**City of Albuquerque Department of Municipal Development  
Comments for DRB Hearing on 12/18/19**

**Project # PR-2019-002184**  
SD-2019-00379---SITE PLAN

**Plat for
 Tract G-1-A
 Academy Place
 Being Comprised of
 Tract G-1
 Academy Place
 City of Albuquerque
 Bernalillo County, New Mexico
 January 2020**

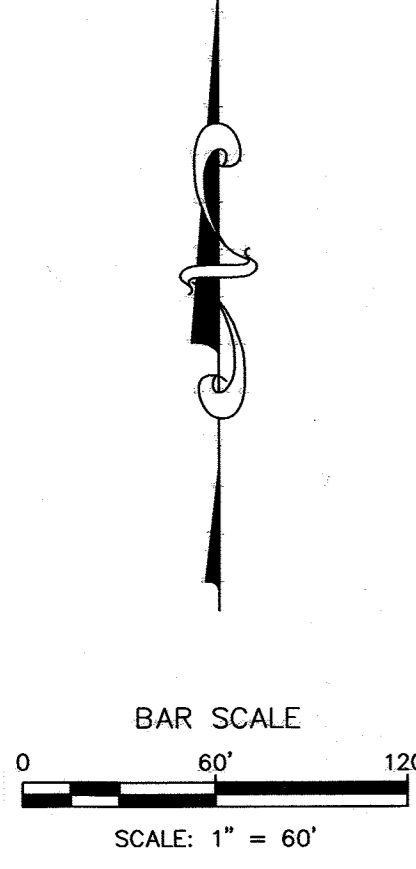
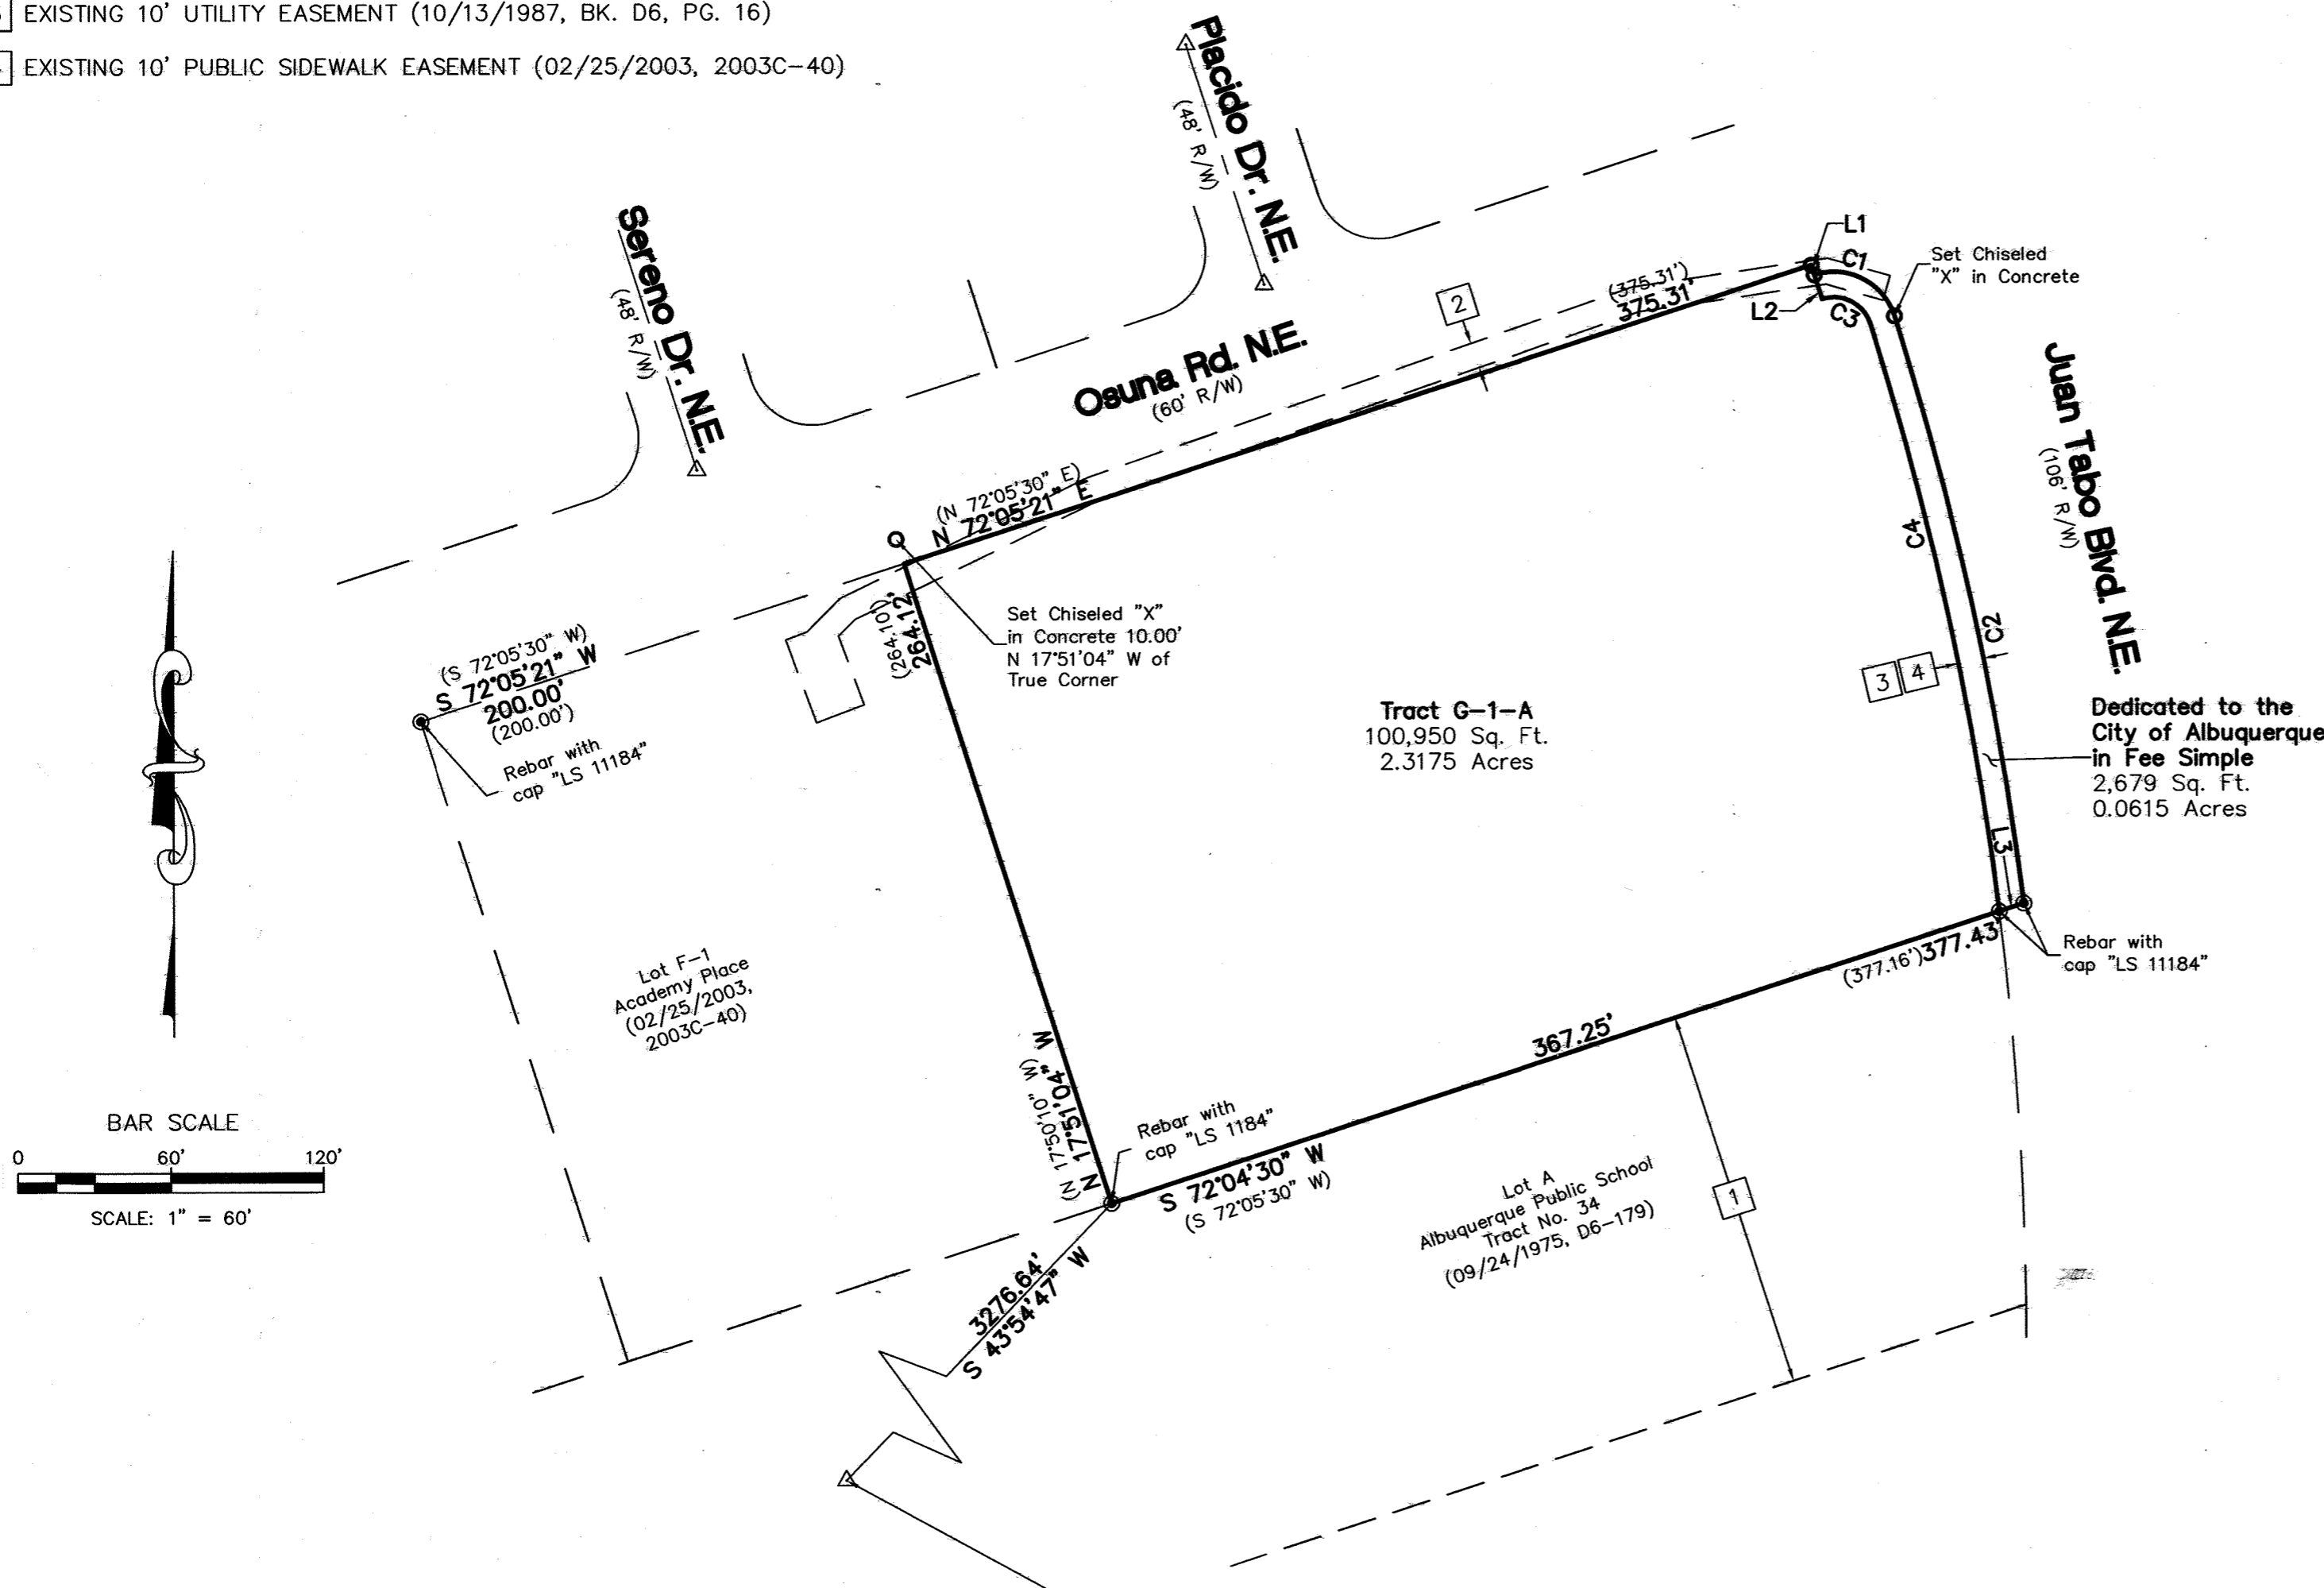
DMD requests a 10 ft. right of way dedication along Juan Tabo Blvd in lieu of the 10 ft. sidewalk easement shown on the plat of record, attached.
